CITY OF ALBUQUERQUE

RE: Starbucks
4301 San Mateo Blvd. NE
Request Permanent C.O. – Accepted
Engineers Stamp Date 2/9/15 (G17D006C)
Certification Dated 10/23/15

RE: Starbucks
4301 San Mateo Blvd. NE
Request Permanent C.O. – Not Accepted
Engineer's Stamp Date 2/9/15 (G17D006C)
Certification Dated 10/23/15

I have reviewed your letter dated October 29, 2015, outlining several items concerning the improvements constructed on the subject site and have included a review of their impact on project.

**C301**

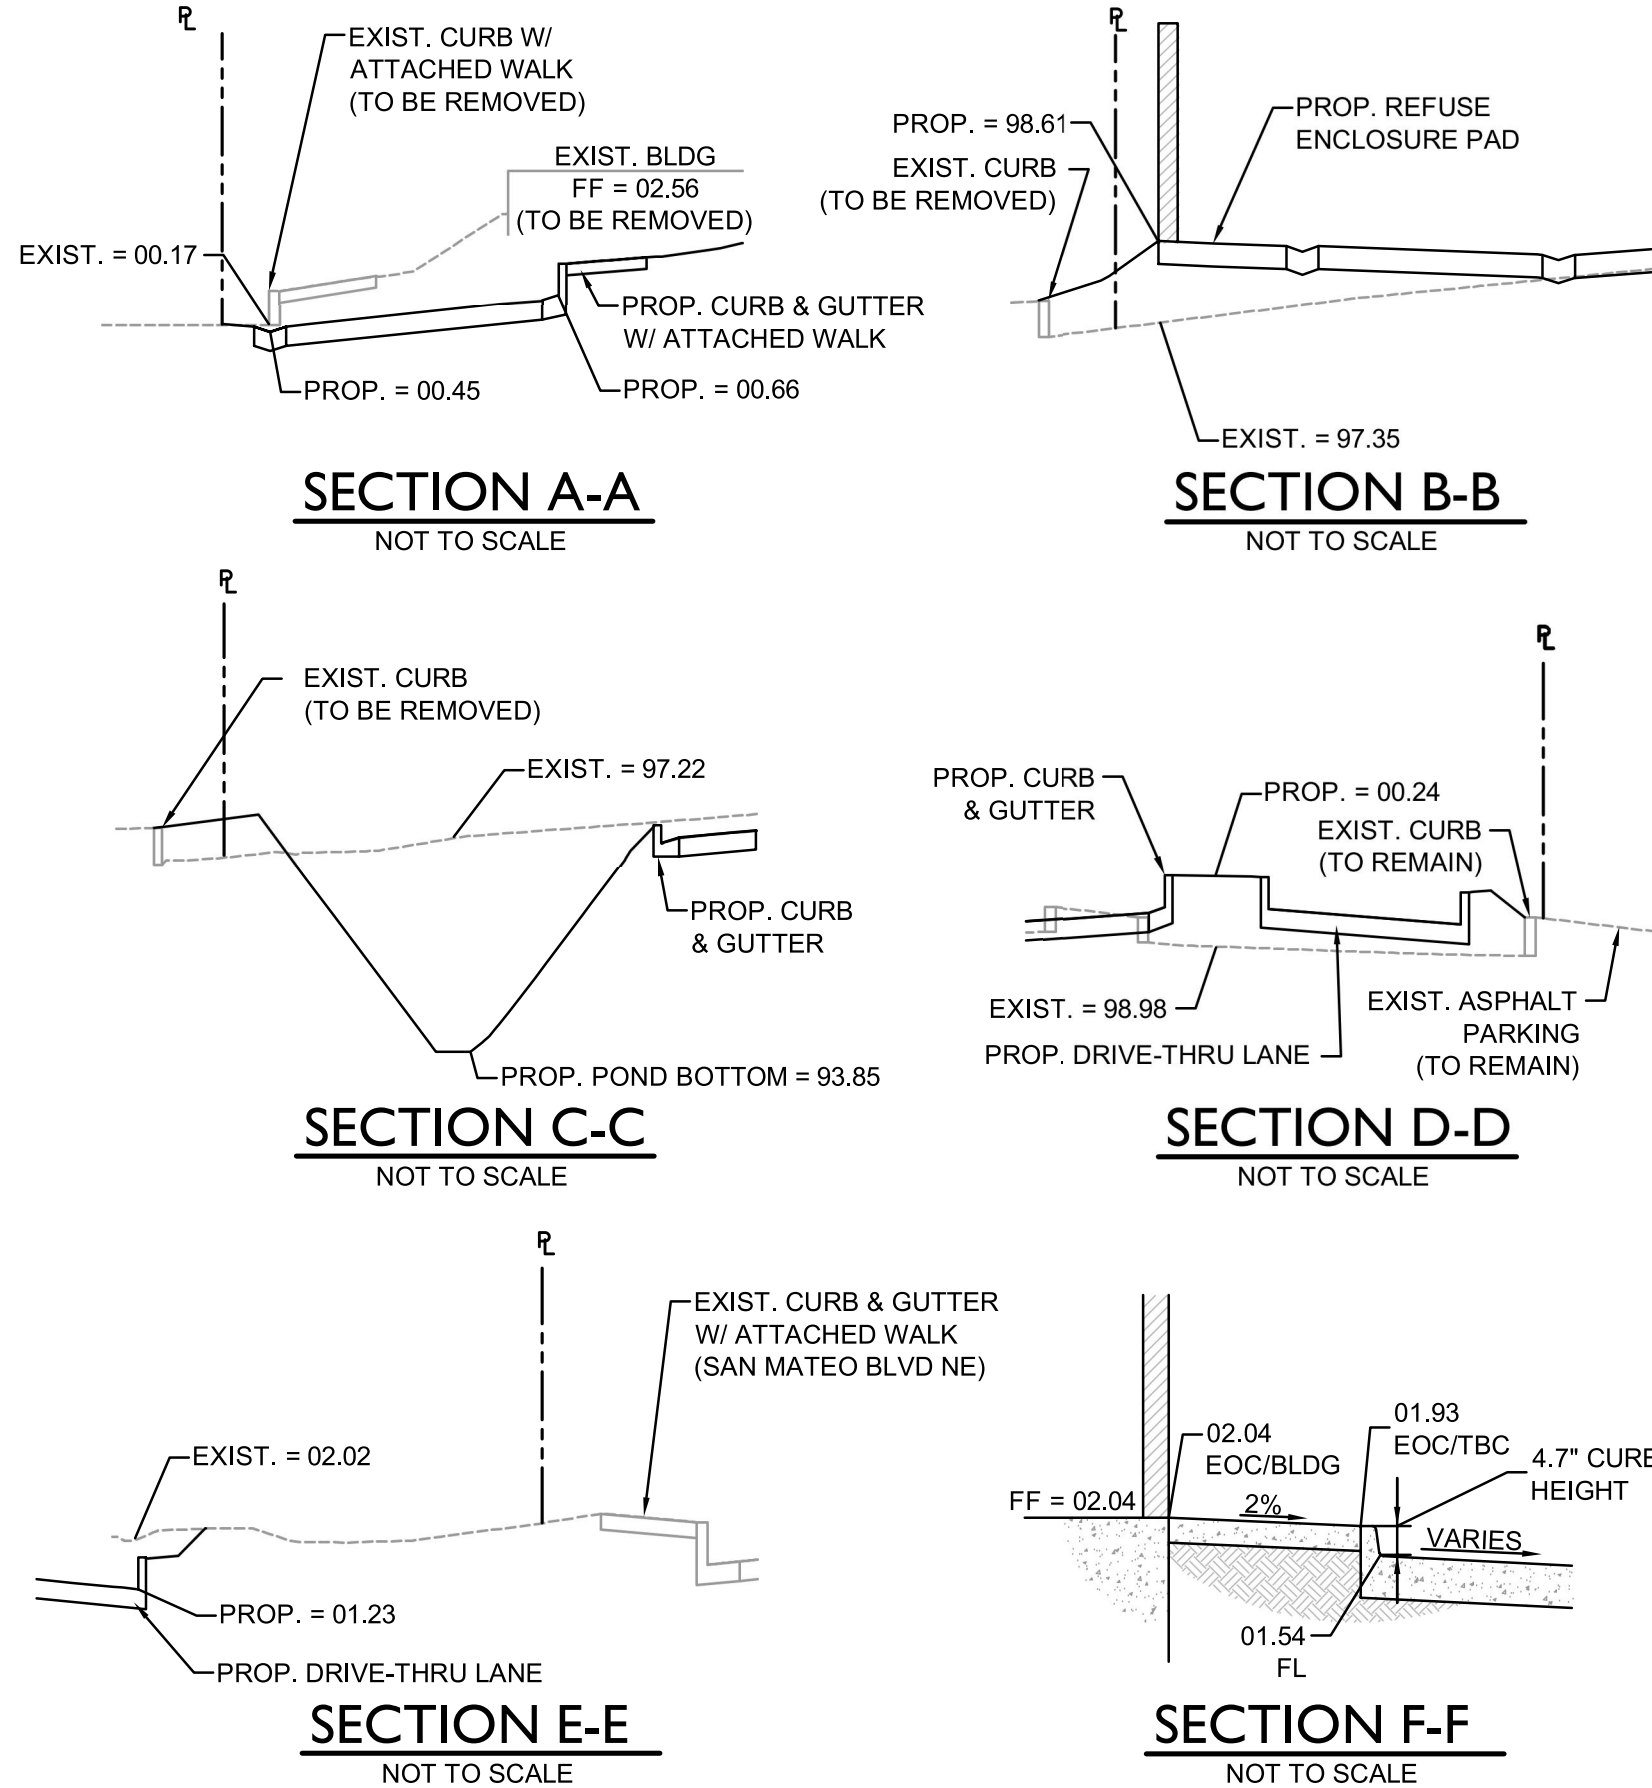
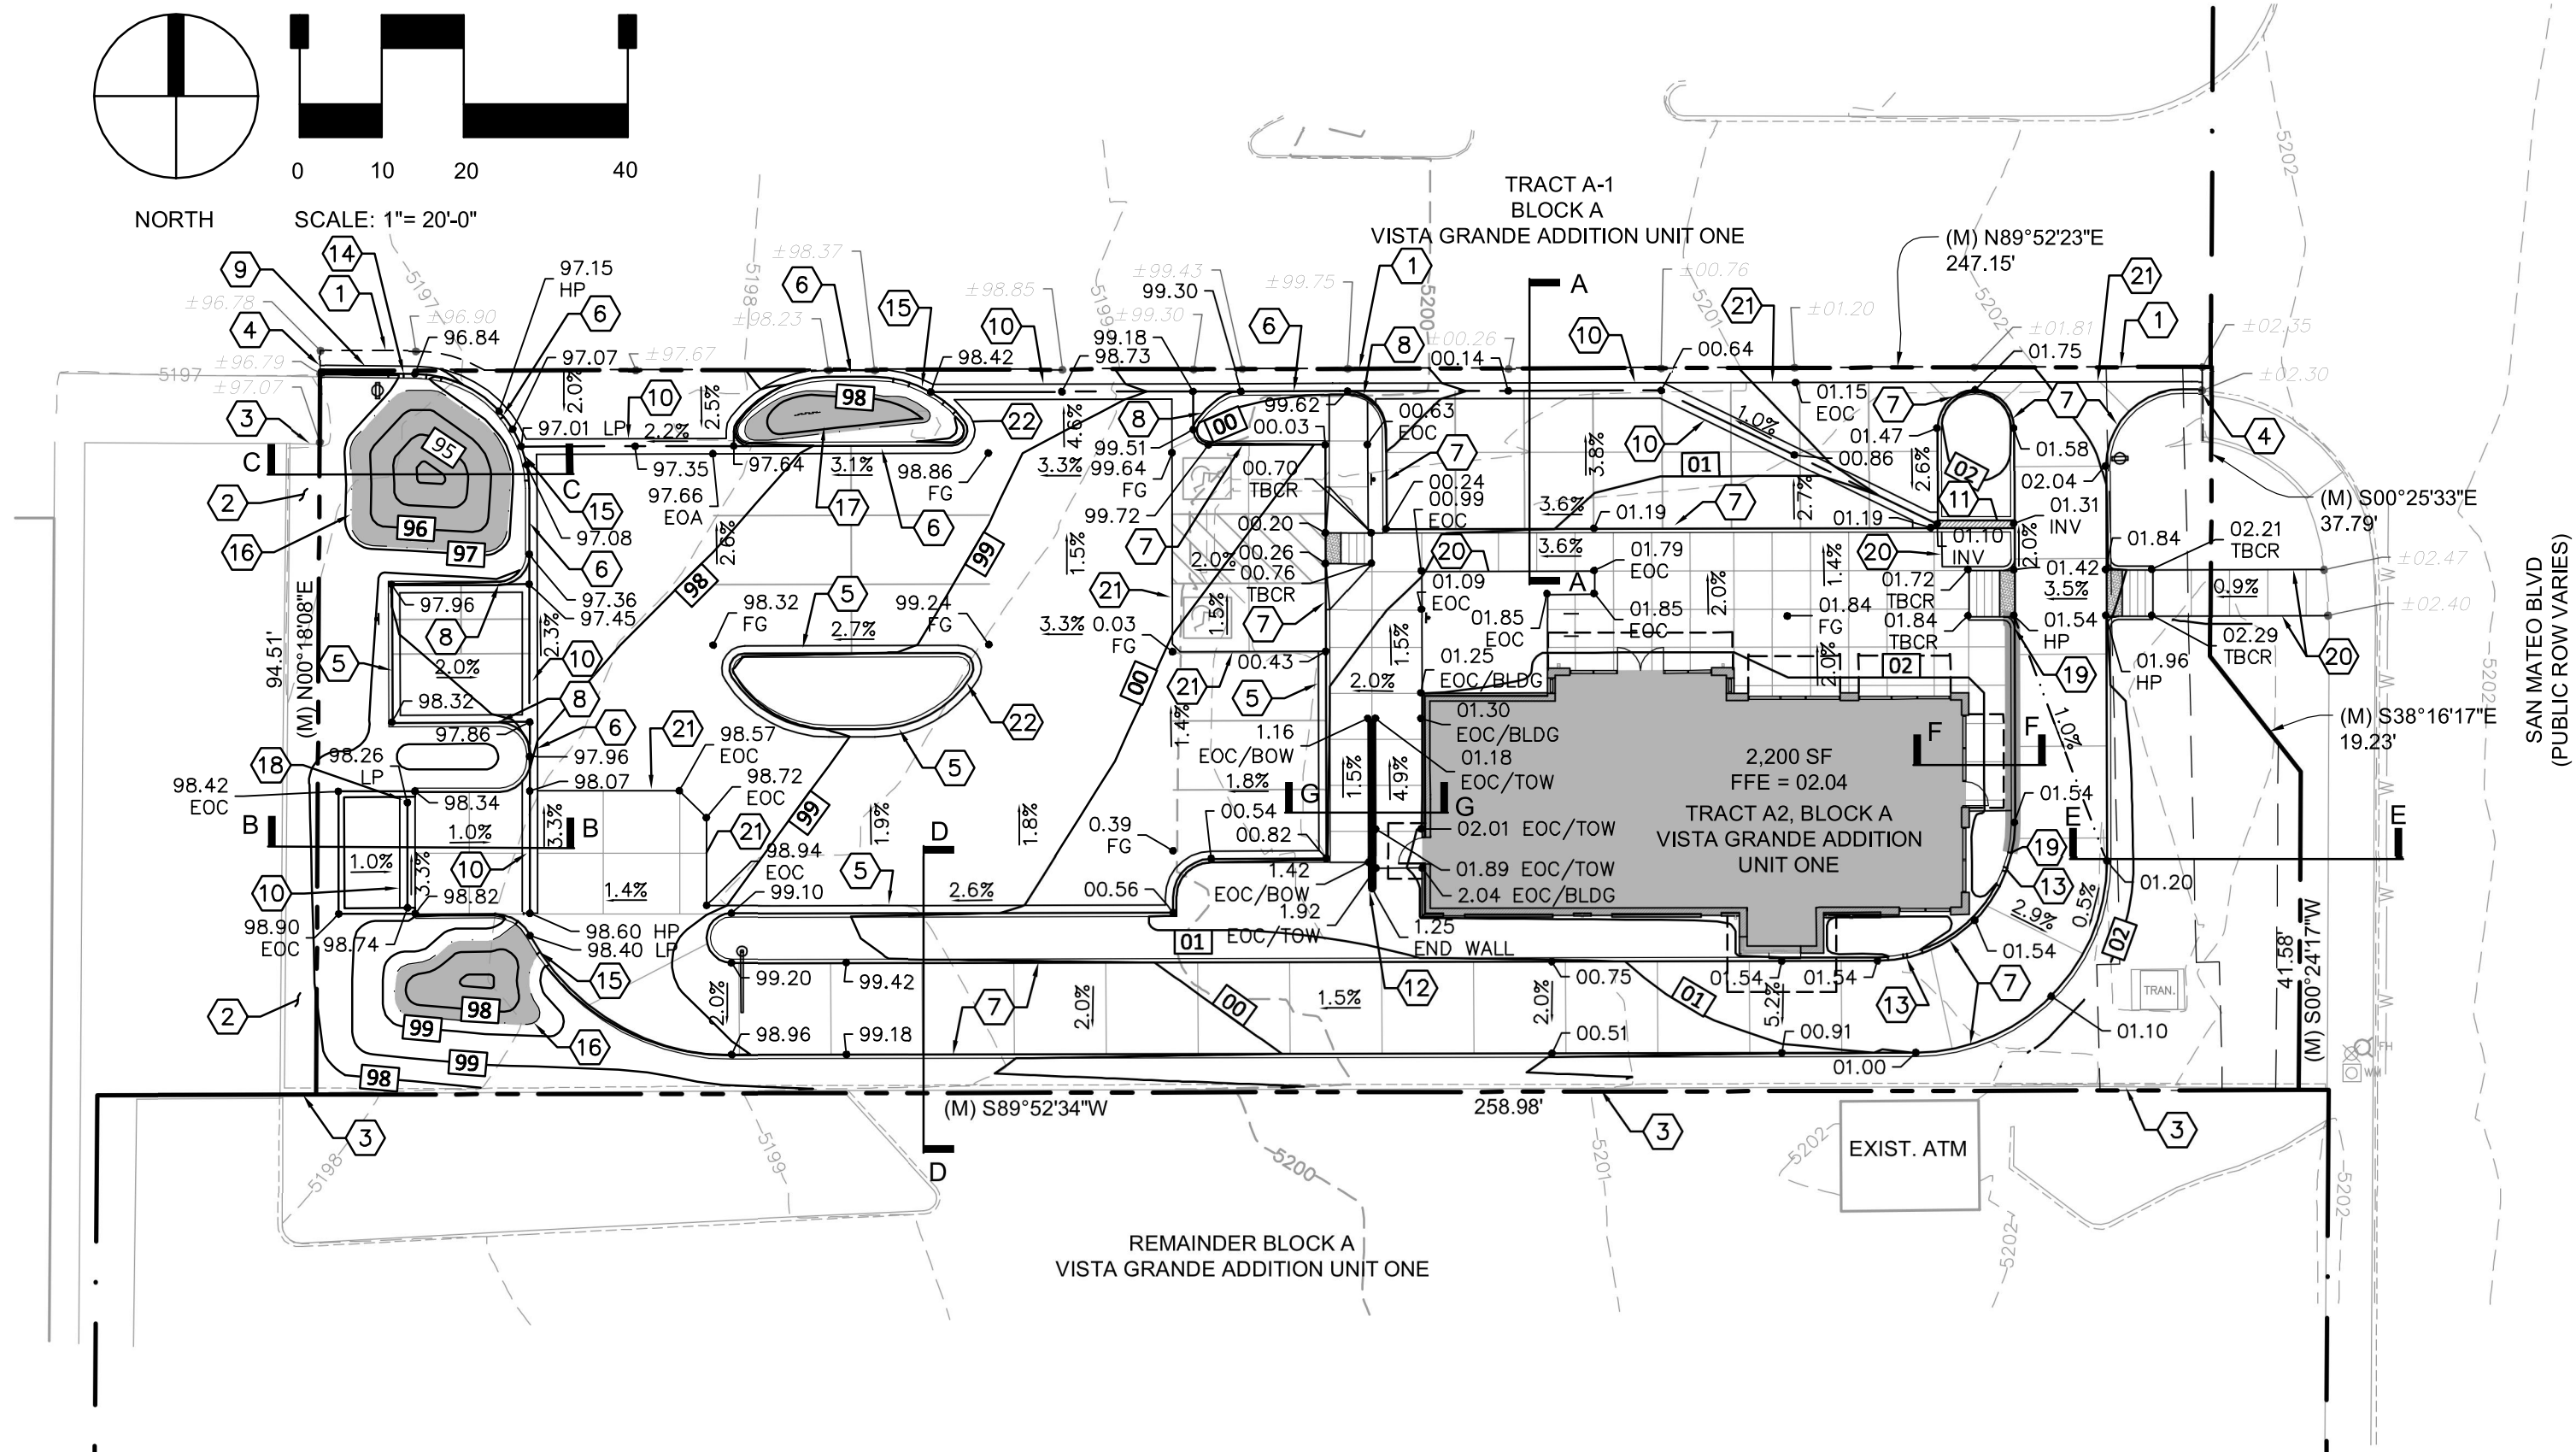
- The concrete sidewalk culvert is not within a paved pedestrian access, but is rather within a landscape area. Therefore pedestrian access across the top of the culvert by use of a steel plate is unnecessary.
- Based on the as-built field shots it appears there is adequate fall from the outlet of the sidewalk culvert across the adjacent downstream parking area. Therefore the 2' wide pan is unnecessary.
- As clarified in separate correspondence, the city's concern is in regard to the 6" curb opening on the "east" end of the building. Inclusion of a 6" curb opening may have provided additional drainage benefits to the adjacent landscape area; however, the lack of such an opening serving a relatively small tributary area should not significantly alter the overall design intent of the grading and drainage aspects of the project as described on the approved plan(s).

As the compliance language on the As-Built Sheet C301, stamped 10/23/15 indicates; these deviations from the grading and drainage design described on the approved plan(s) represent discrepancies which are minor in nature and/or should impact maintenance of the property rather than the overall drainage design intent.
